Glenarm Site Development Plan, PPR-20-26

Please accept the following comments from El Paso County Public Health regarding the project referenced above:

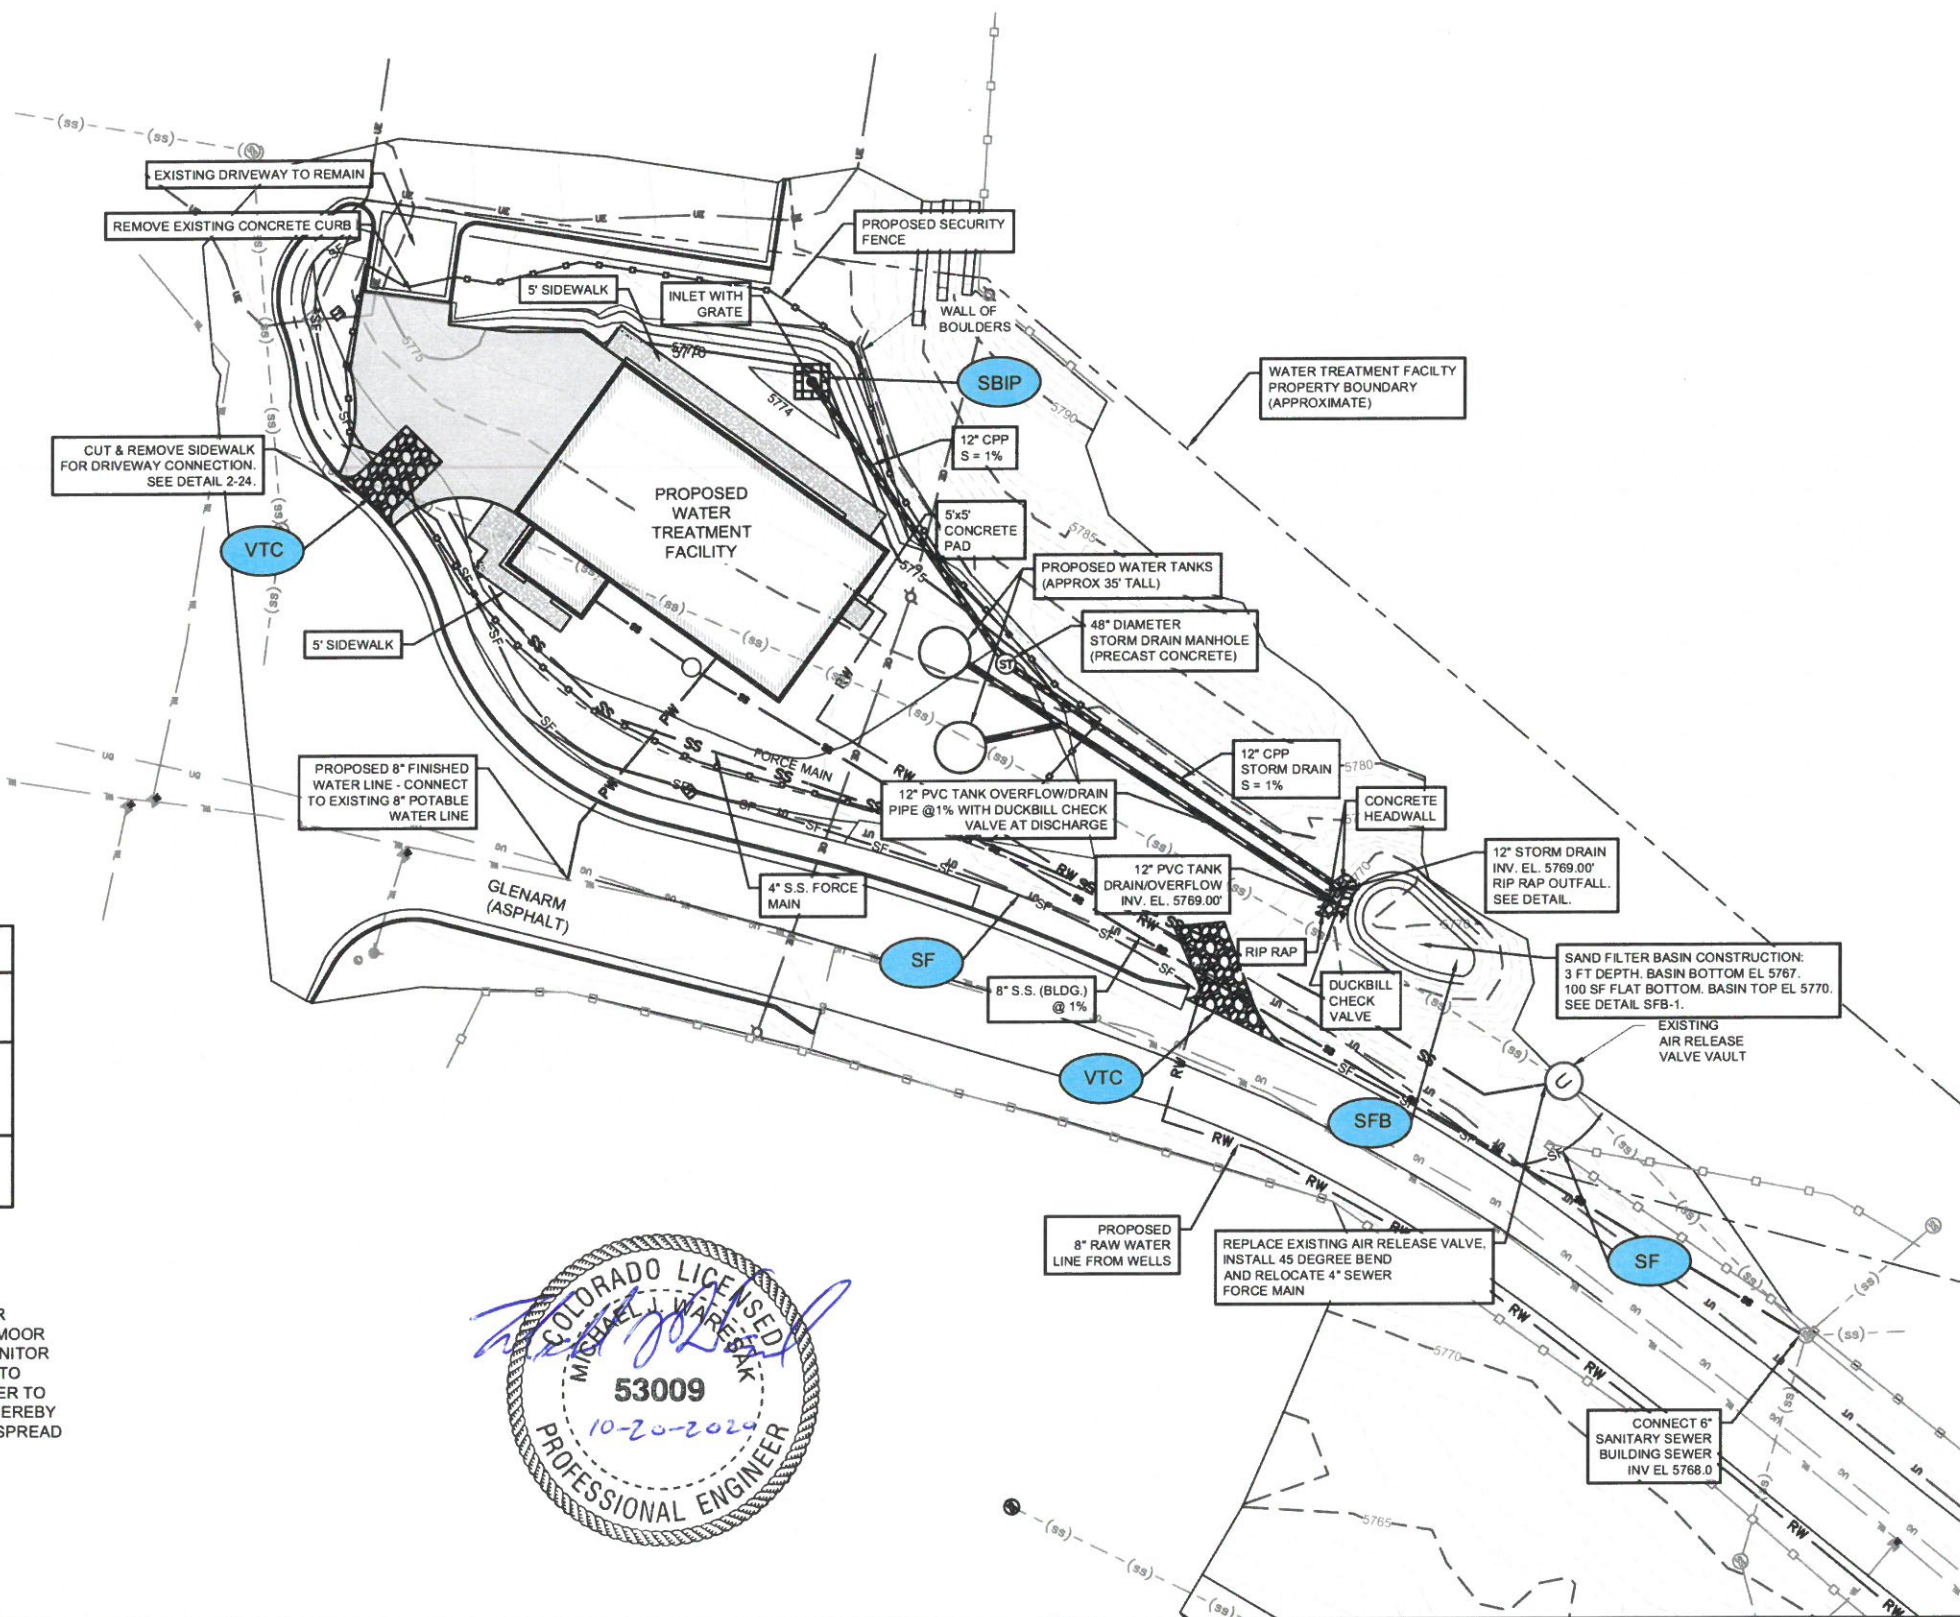
- The centralized water treatment facility for Stratmoor Hills Water District must meet the design criteria and the rules and regulations of the Colorado Department of Public Health and Environment (CDPHE), Water Quality Control Division (WQCD), for water system construction and materials.
- Earthmoving activity in excess of one acre, but less than twenty-five acres, requires a local Construction Activity Permit from El Paso County Public Health. Go to <https://www.elpasocountyhealth.org/service/air-quality/construction-activity-application> for more information.
- The water quality basin must have mosquito control responsibilities included as a part of the construction design and maintenance plan to help control mosquito breeding habitat and minimize the potential for West Nile Virus.
